City of Portland, Maine - Building or Use Permit Application

Permit No: 03-0360	Issue Date: MAY 29 2003	CBL: 339 D011001
-----------------------	----------------------------	---------------------

Proposed Project Description:
Build 26'x32' single family dwelling

RE: 39 Barclay Avenue – 339-D-011 &012 – R-3 Zone – Permit # 03-0360

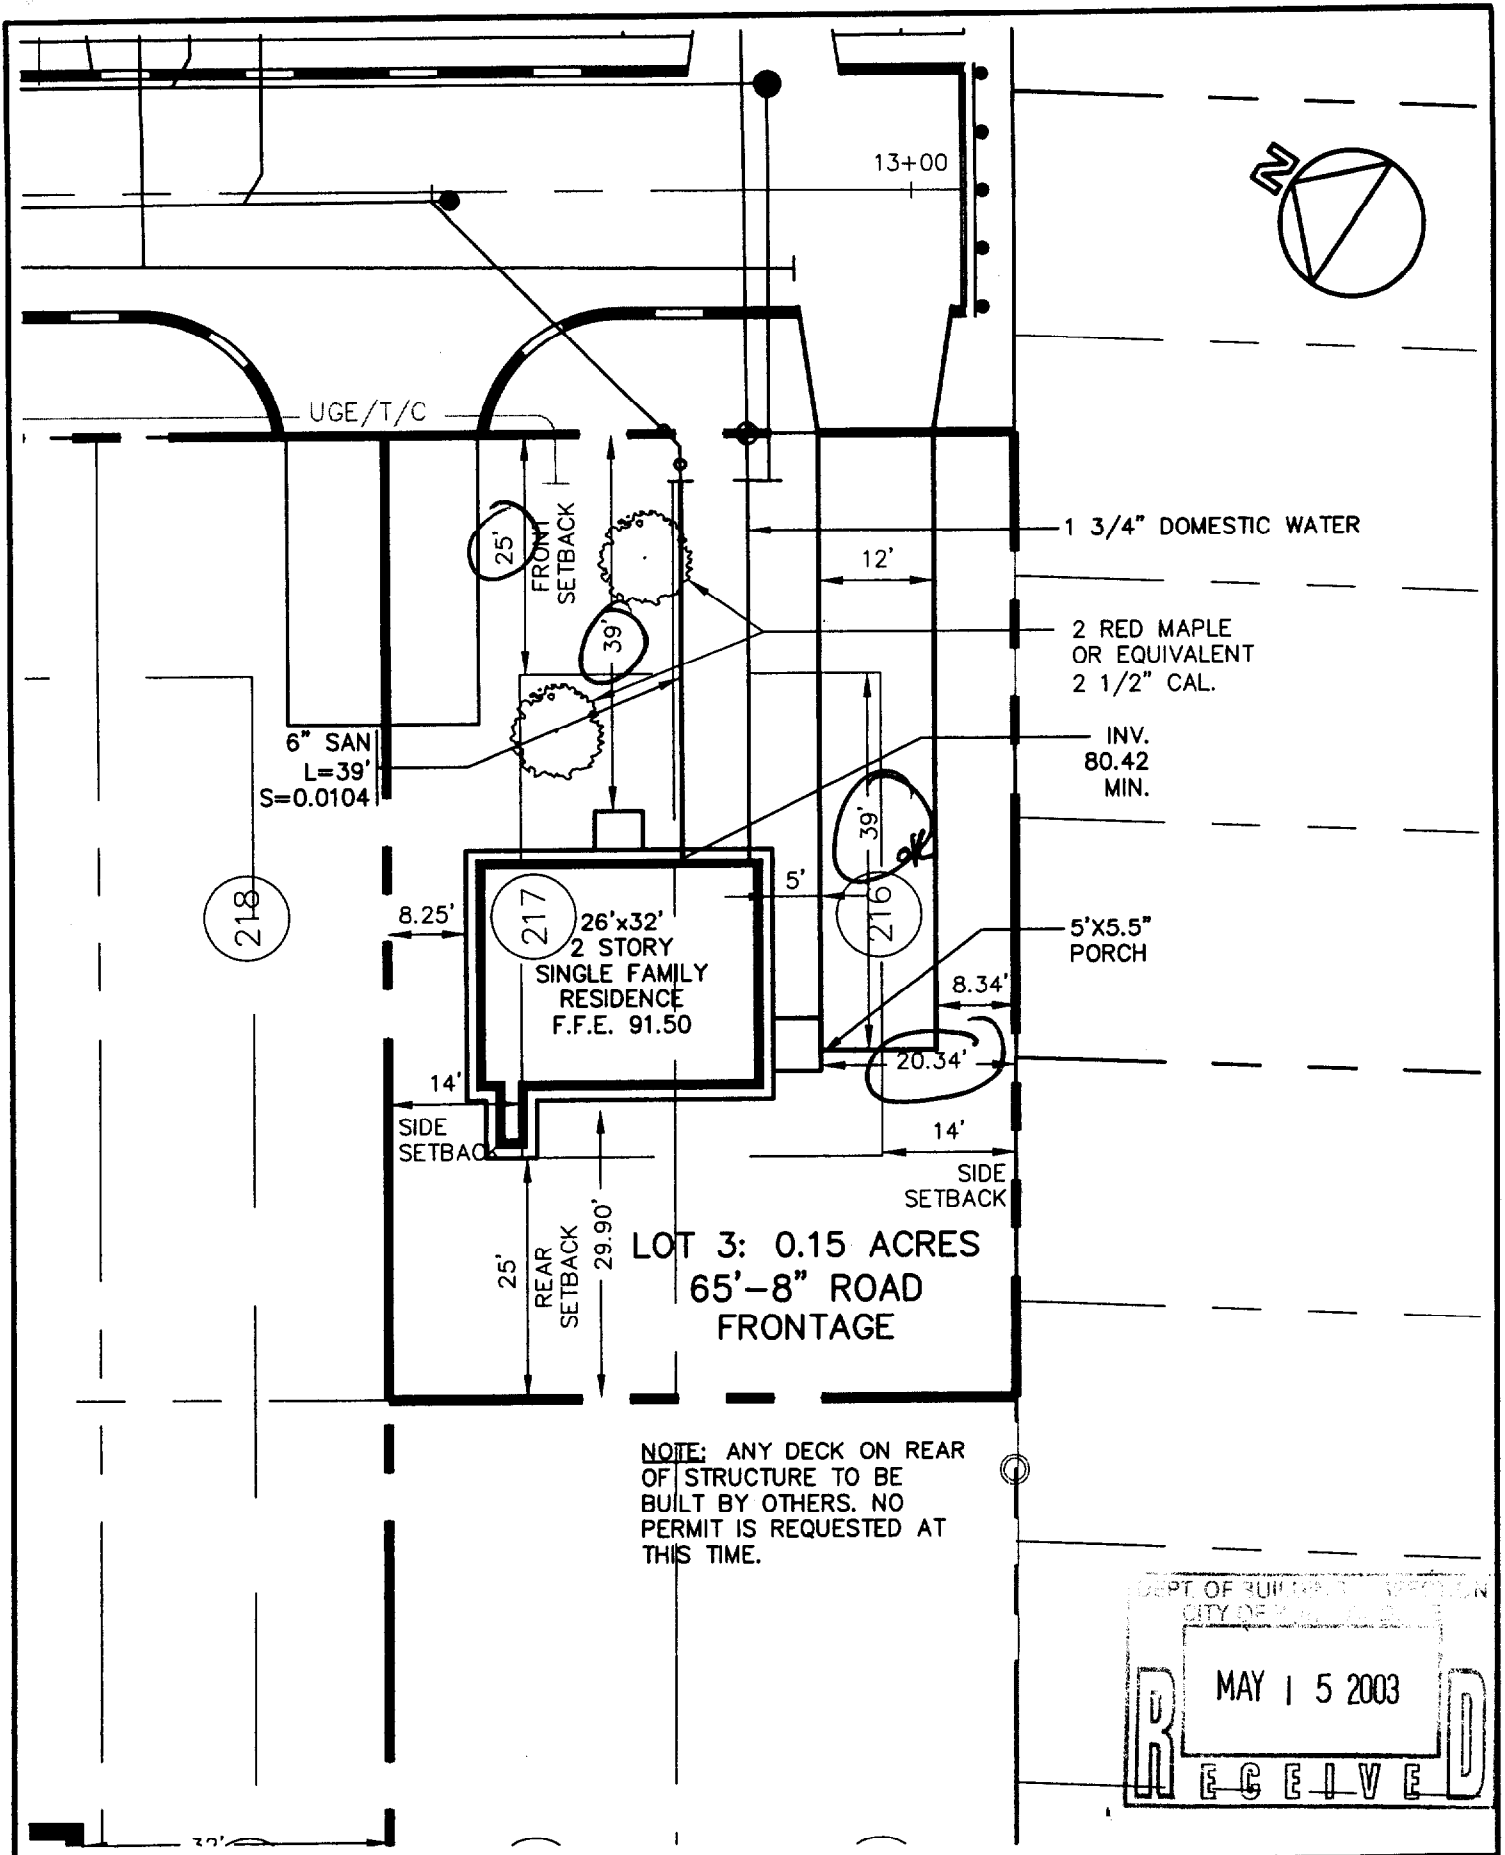
Note: 5/7/03 all zoning except the parking is ok - showing 35' from front setback instead of the 39' required for two Ok to Issue:
 (2) parking spaces will write letter
 5/15/03 revised plans show 39' feet beyond the front required front setback

I am in receipt of your permit application to construct a 26' x 32' single family dwelling. Your plans are only showing a parking area of 12' x 35' beyond the front setback line. The standards for a parking space is 9' x 19'. Therefore, two in-line spaces would require a length of 39'. If you revise your plans within 30 days of the date of this letter, I can accept that change as part of this application.
